THIRD FLOOR FRAMING PLAN
1/4"=1'-0"

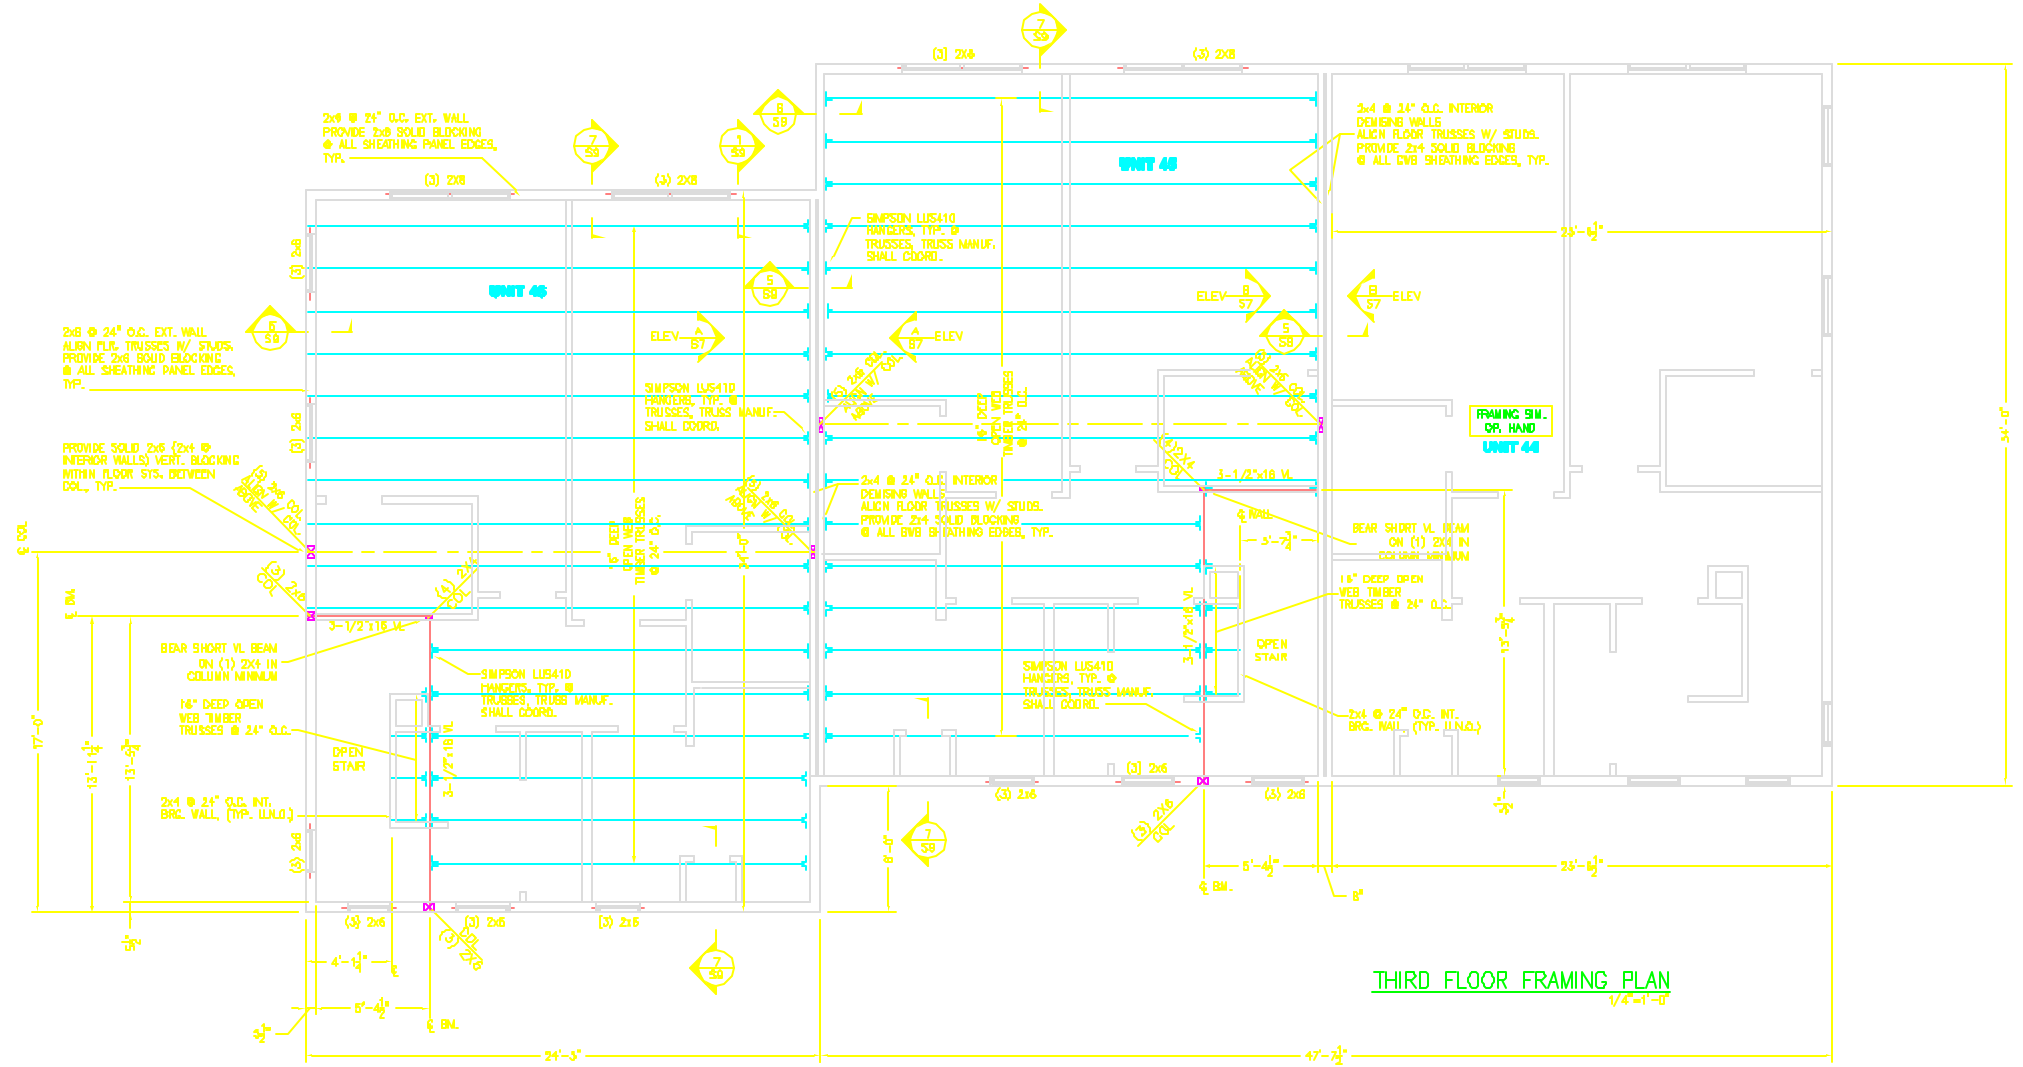
Attic or additional Floor Joist Species Dimensions and Spacing (Table 802.4.2 or 503.3.1(1) & Table 503.3.2(1))			
Roof Rafter: Pitch, Span, Spacing & Dimension (Table 802.3.2(7))	VL R1D W 2x4	12' SPAN - TABLE 802.5.1 12' SPAN	
Sheathing; Floor, Wall and roof (Table 503.2.1(1))		FLOOR 3/4" PLY ROOF 5/8" PLY	1/2" Ply PLYWOOD PLYWOOD W/ GYPSUM
Fastener Schedule (Table 602.3(1) & (2))			
Private Garage Section 309 and Section 407 1999 BOCA) Living Space? (Above or beside)		5/8" FIRE CODE GWB W/ MUST CEILING	
Fire separation		1 HR DOOR	
Fire rating of doors to living space Door Sill elevation (407.5 BOCA)			
Egress Windows (Section 310)		FULLY SPRINKLED	
Roof Covering (Chapter 9)		30 YEAR ASPHALT	
Safety Glazing (Section 308)		ON AP BY NOT SHOWN ON SHEETS	DOOR TEMPERED
Attic Access (BOCA 1211.1)		ATTIC AREA OVER 30'	NOT SHOWN
Draft Stopping around chimney		NOT SHOWN

NEED STAIR & FIRE RACK
W/ P

INTERIOR FINISHED WALLS
w/ 3/4" HANDRAILS
NEED EXTERIOR
CORNER DETAILS
